Yorkshire Green Energy Enablement (GREEN) Project

**Document 8.25.1 Applicant's Response to Examining Authority's
Second Written Questions (ExQ2)**

Planning Inspectorate Reference: EN020024

Plan View 4
Low Loaders passing
Scale 1:200

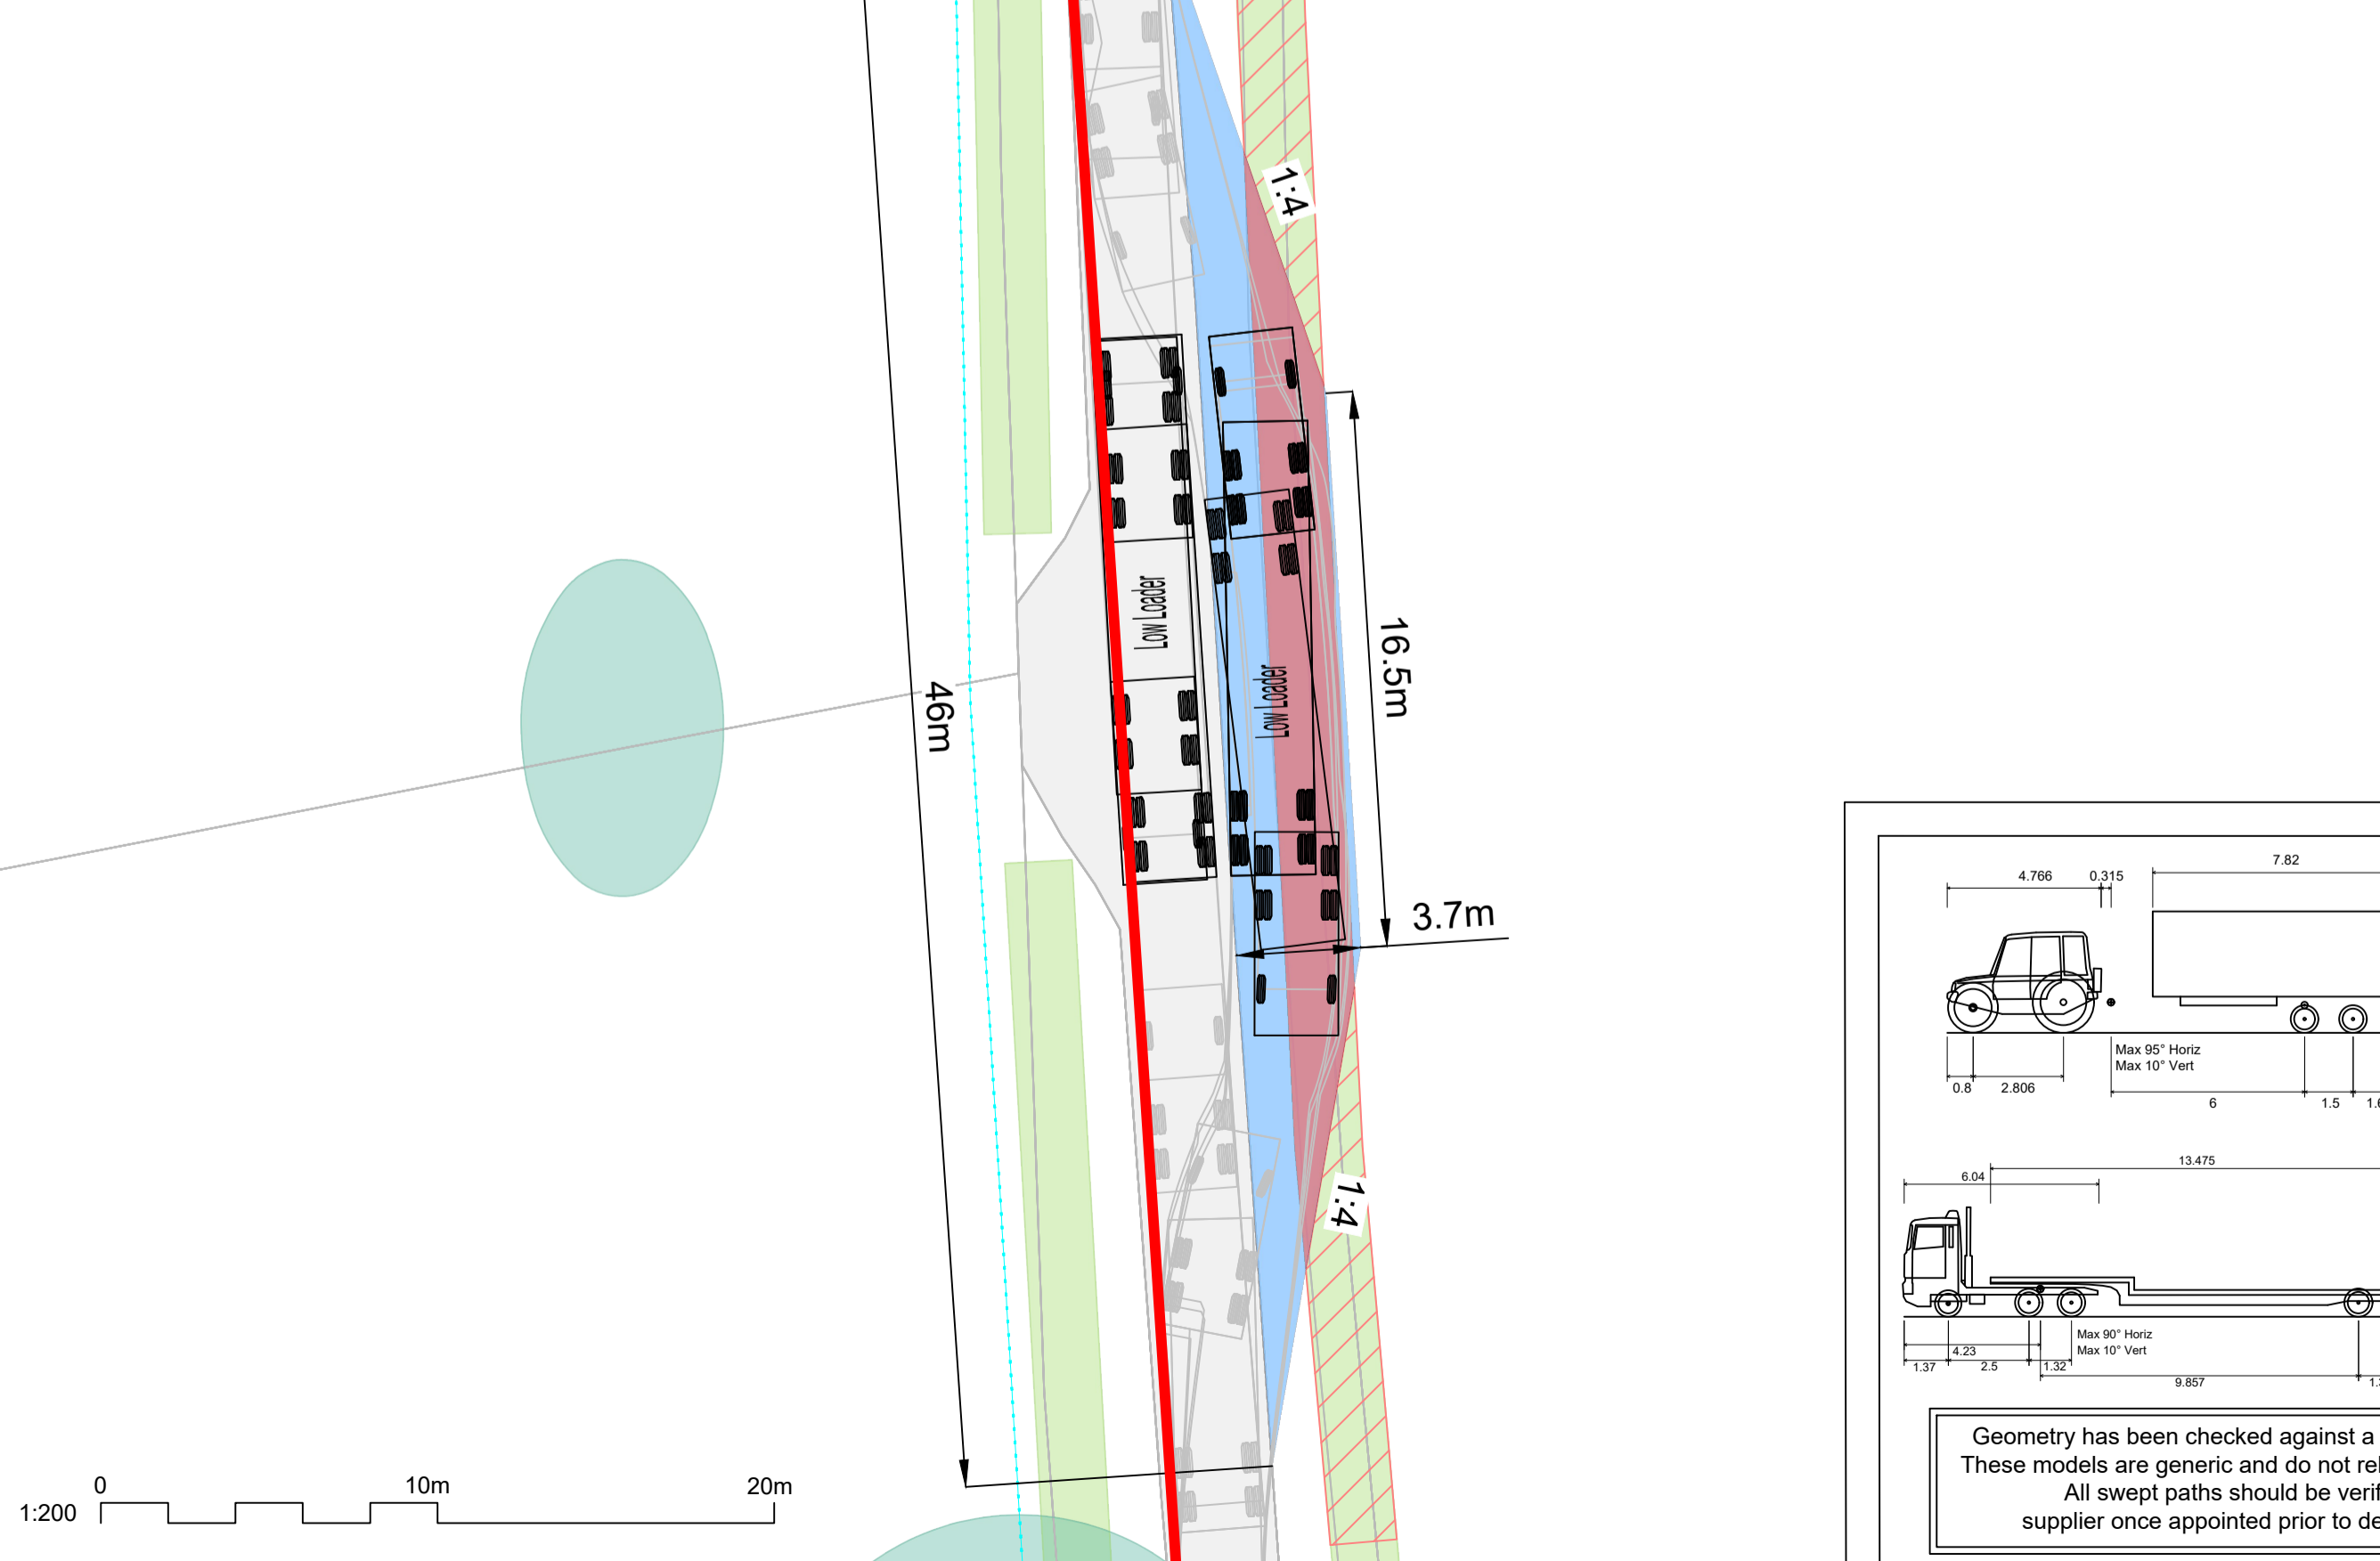
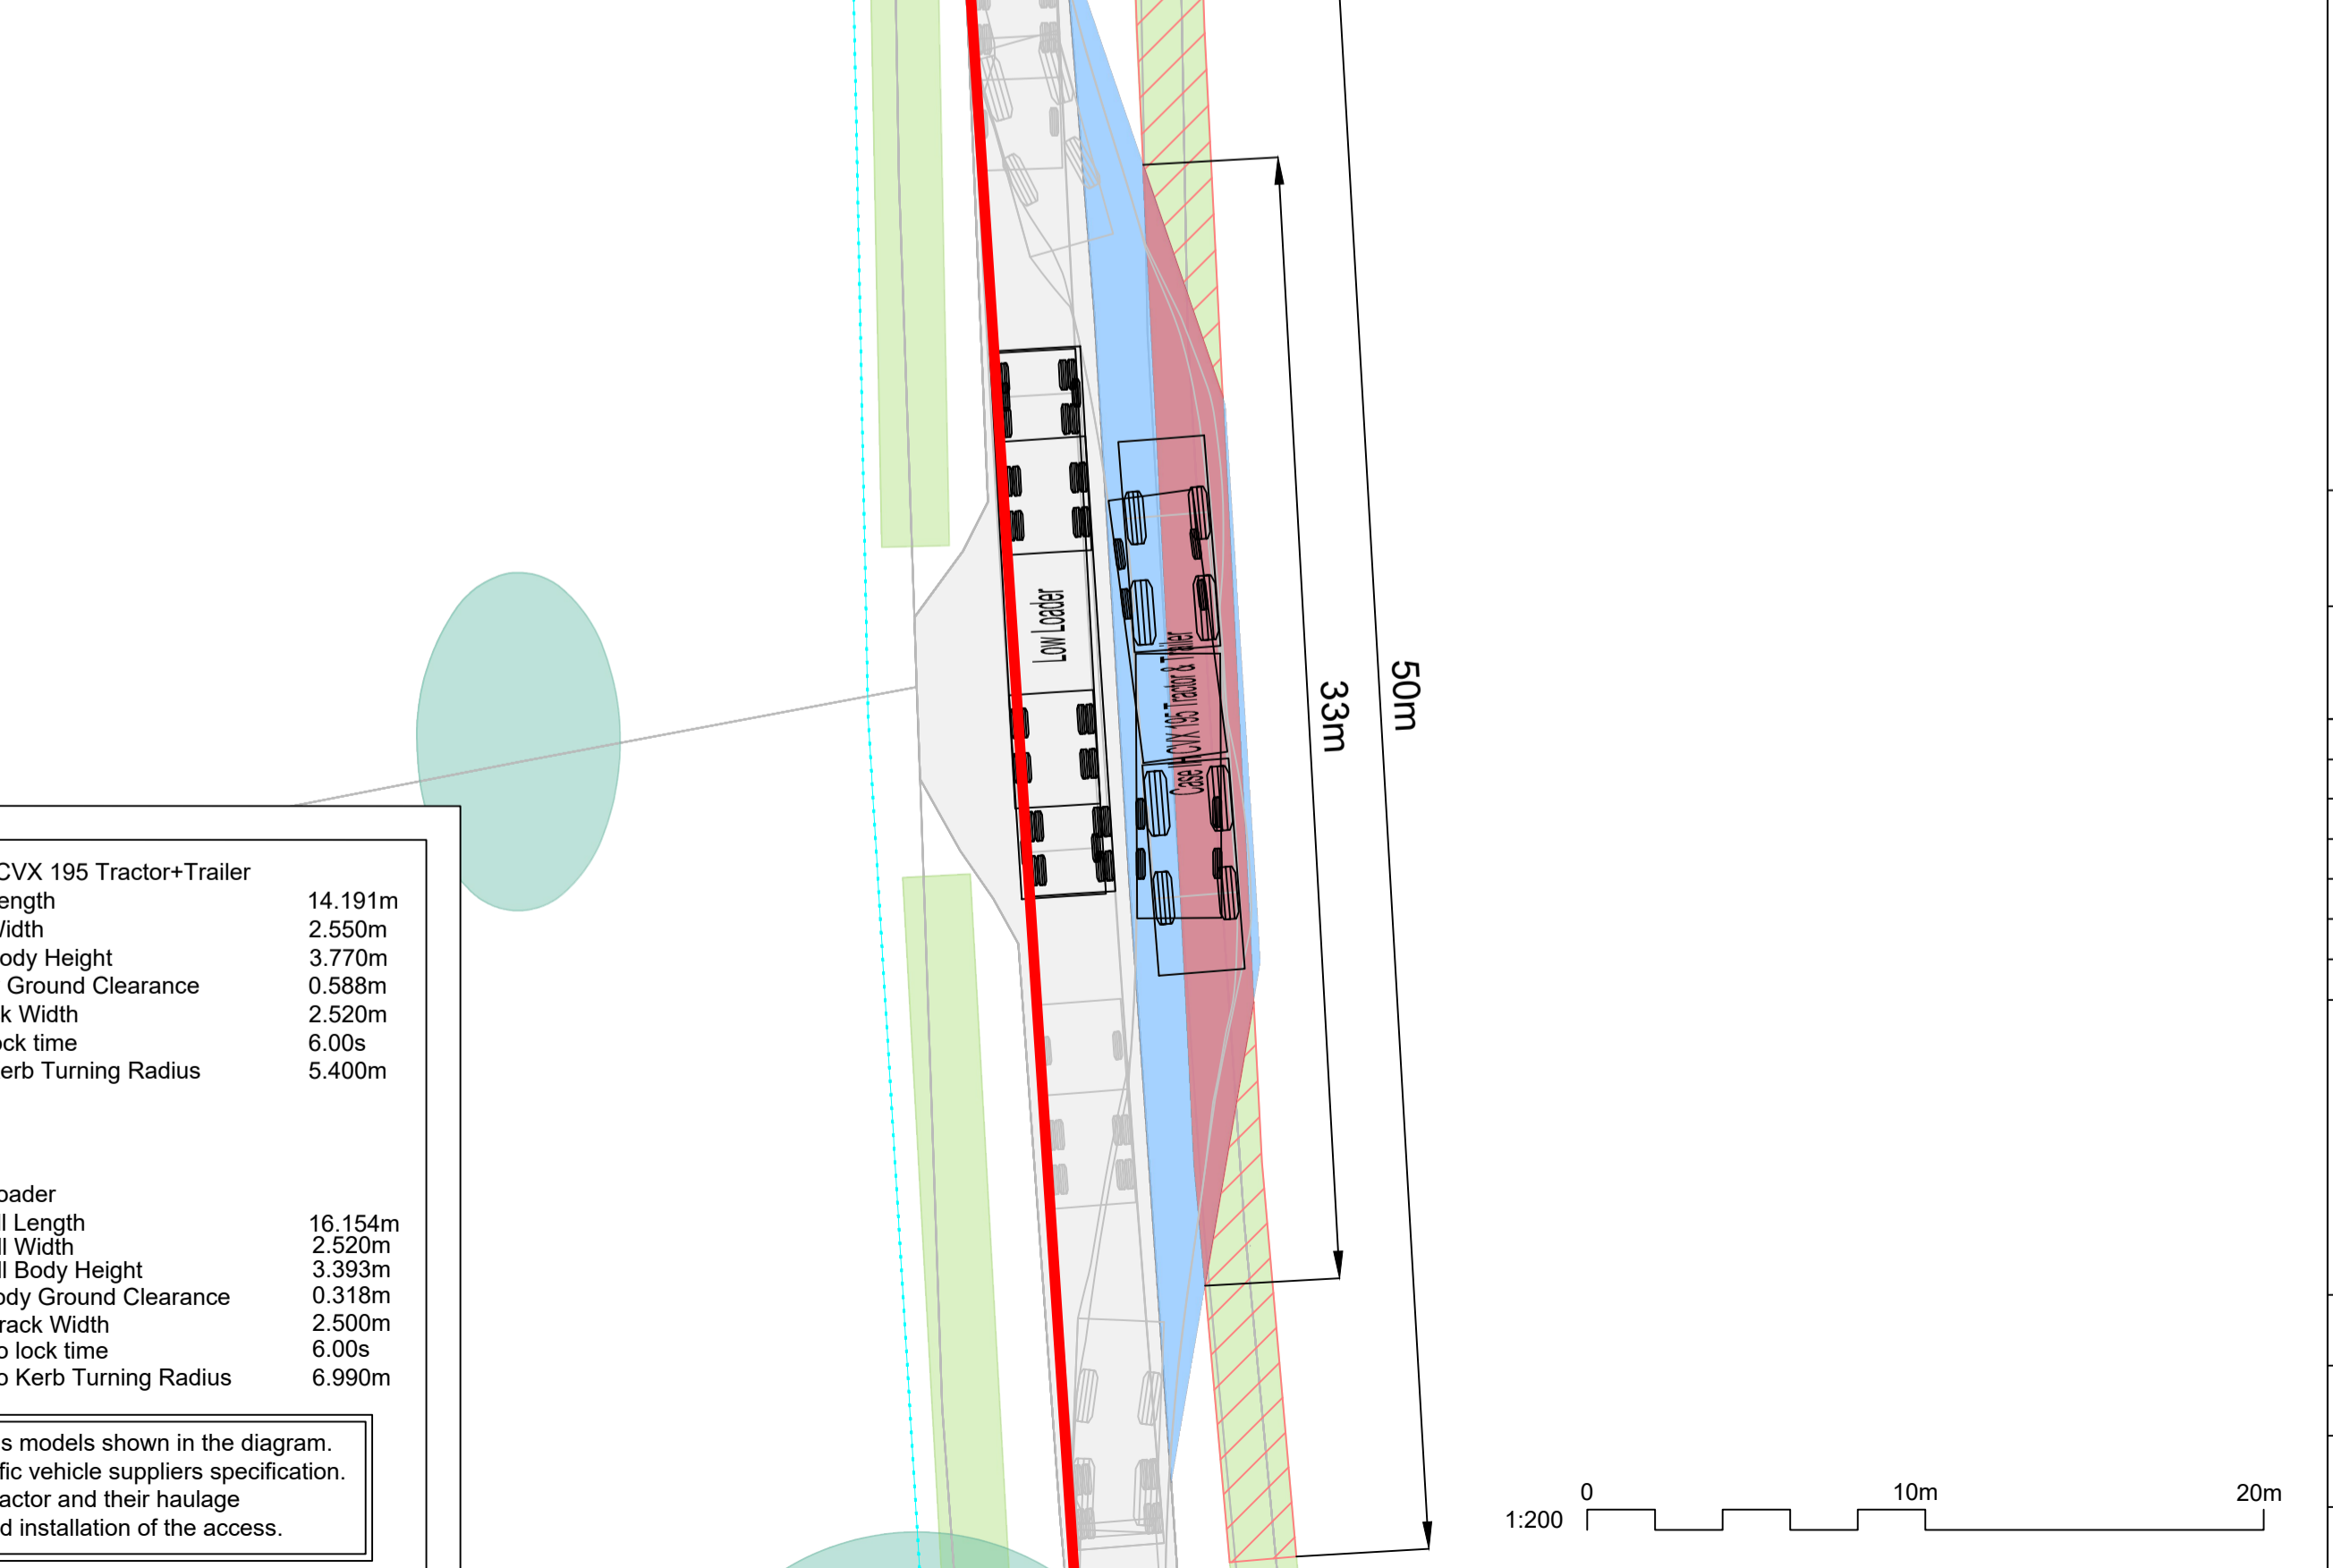
Ref No.	Respondent:	Question:
1.3	1.3 Post-hearing submissions	
Q1.3.1	The Applicant	<p>Illustrative Plan: SP005 Access During Construction Phase [REP4-026], Appendix D</p> <p>The ExA notes this is an illustrative plan, as requested.</p> <ol style="list-style-type: none"> a) Is this the sort of plan which would form part of the tree and hedgerow protection strategy (THPS) for approval by the relevant planning authority? b) If so, would there be clarity on the areas for hedgerows to be removed at the time of submission for approval? c) Has this illustrative plan taken account of the Northern Powergrid undergrounding works which would precede the traffic management works, if required? d) If not, what would the process be for seeking approval from the relevant planning authority for those pre-commencement works? <p>Applicant’s Response:</p> <ol style="list-style-type: none"> a) This type of plan would not form part of the THPS but is the type of detail that would inform the development of the THPS (as part of a suite of design information to allow tree loss or impacts to be finalised). The THPS would include an Arboricultural Method Statement, Tree Protection Plan (showing the final extent of tree loss/retention and position of fencing or ground protection), schedule of tree works (including pruning and removal) – e.g., an updated version of the schedule in Annex 3I.2 submitted with the Arboricultural Impact Assessment (Document 5.3.3I(B)), [REP4-009 to REP4-011]. This would take into account the final design and any other supporting information, such as that obtained from a site walkover, as required. b) The THPS would show the final extent of tree and hedgerow loss for each stage of the Project which would be the subject of approval under Requirement 9 of the DCO. If there was any change required during works following the approval of the THPS e.g. due to the flexibility in the limits of deviation, this would be discussed with the relevant LPA and consent would be obtained in advance of any additional tree works taking place, if required. This accords with the Biodiversity Mitigation Strategy (Document 5.3.3(D)) Appendix 3D [APP-097] which states in section 3.3. that <i>‘any deviations from the plan will be agreed in advance with the ECoW and relevant stakeholders (i.e. Local Planning Authority) where necessary, with advice from an appropriately experienced and qualified arboriculturist where required’</i>.

Ref No.	Respondent:	Question:
		<p>c) and d) The plan provided in Appendix D [REP4-026] assumes that any undergrounding of the Northern Powergrid lines has already been undertaken. The plan is only intended to show an illustrative view of what any bellmouth and passing places could look like, and if any hedge removal would be needed to facilitate the works.</p> <p>Should the utility works and diversions be undertaken as pre-commencement work under Requirement 1(i – diversion and laying of underground apparatus and utilities)) of the draft DCO (Document 3.1 (D)), no trees or hedges would be removed pre-commencement but could be coppiced or pruned if required. Requirement 5(3) of the draft DCO (Document 3.1 (D)) identifies that all pre commencement work must be carried out in accordance with the Construction Management Plans, including the Code of Construction Practice (CoCP) and the Biodiversity Mitigation Strategy (BMS) which are listed in Requirement 5 and therefore are secured in respect of pre commencement works. The BMS includes elements covering vegetation loss and reinstatement. In paragraph 3.3 it states that tree loss will be as per the Arboricultural Impact Assessment and Tree Removal and Protection Plan but notes that <i>‘any deviations from the plan will be agreed in advance with the ECoW and relevant stakeholders (i.e. Local Planning Authority) where necessary, with advice from an appropriately experienced and qualified arboriculturist where required’</i>.</p> <p>Tree and hedgerow removal is not anticipated pre-commencement, however in the unlikely event that tree loss was required, as per the BMS National Grid would be required to agree any deviations with the Local Planning Authority in advance.</p>
